App No: BR/248/19/PL

Address: Homelands Care Home 21 21-23 Richmond Avenue Bognor Regis

Proposal: Alteration to the existing building to provide 6 No. additional bedrooms with en-suites to include two storey rear extension & conversion of 2nd floor loft space & dropped kerb.

PROPOSED REAR ELEVATION 1:100 PROPOSED SECTION B-B REAR 1:100

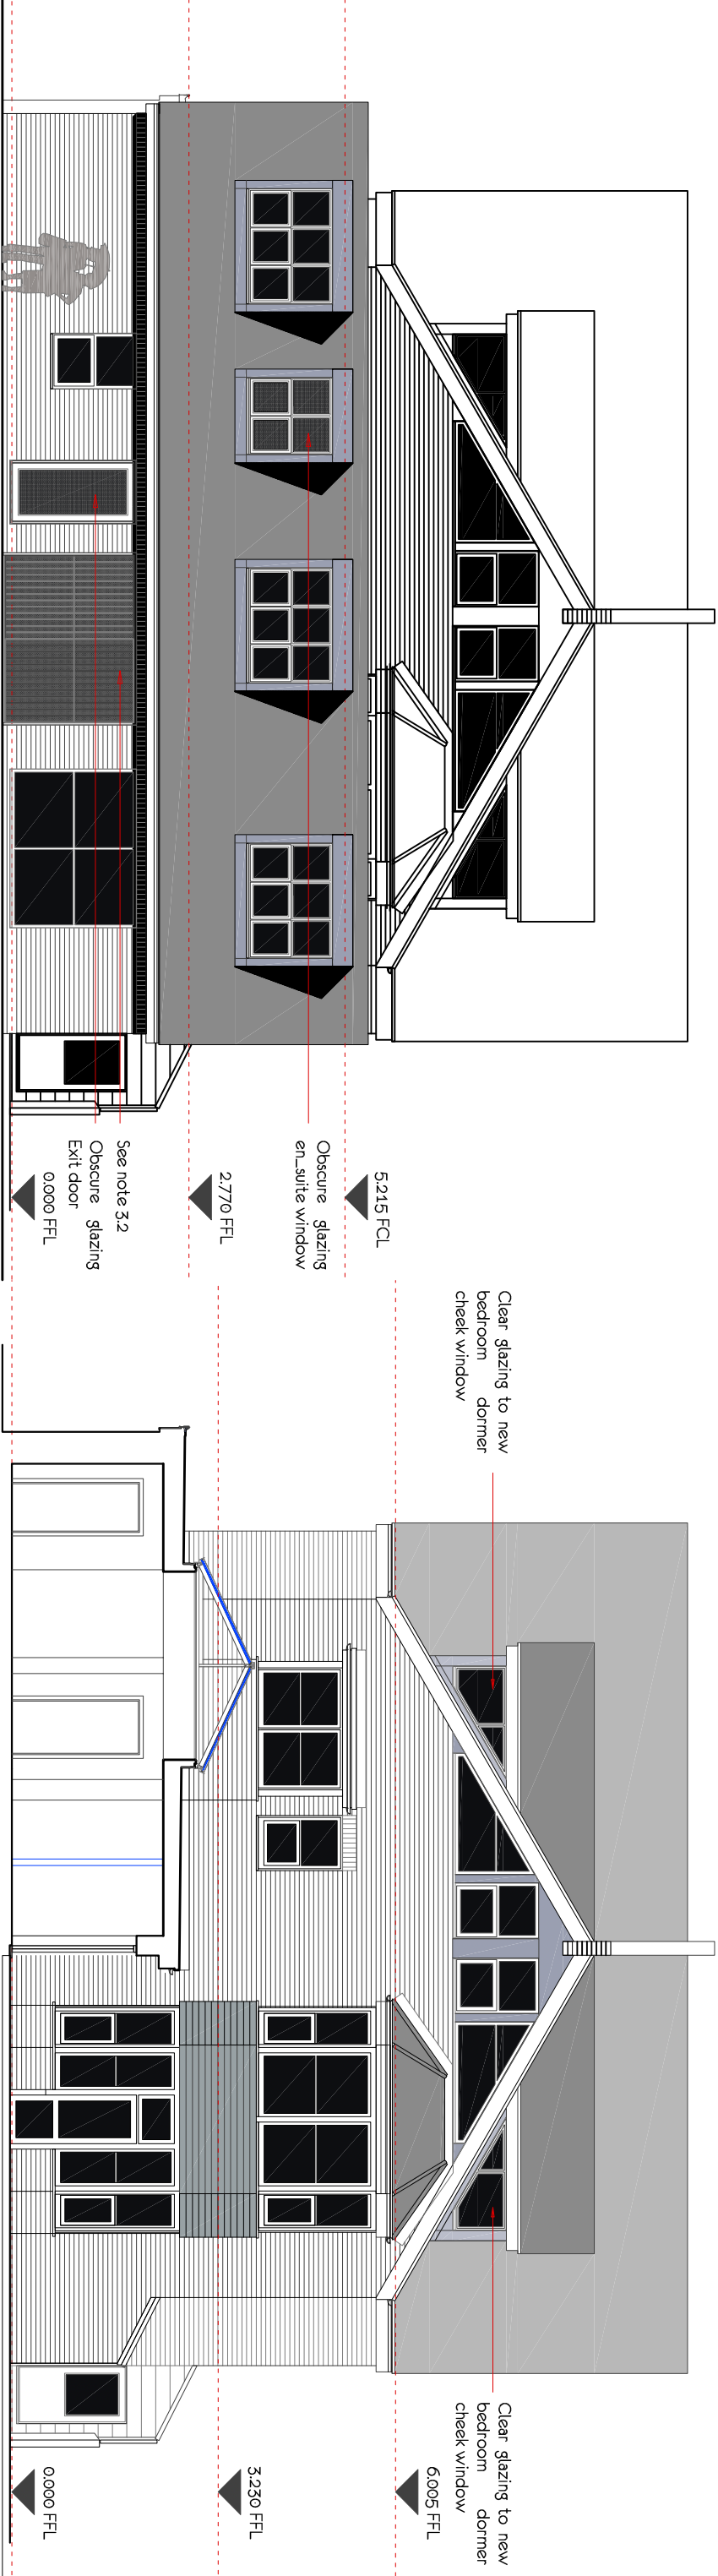
As detailed within the Bat Survey Report (Nov 2019) a precautionary approach should be undertaken and following an inspection by an ecologist prior to works commencing, removal of the roof tiles should be undertaken by hand in the presence of a suitably qualified ecologist. If a bat is found all works must stop and Natural England consulted.

We require that a bat box is installed on the buildings onsite facing south/south westerly positioned 3-5m above ground.
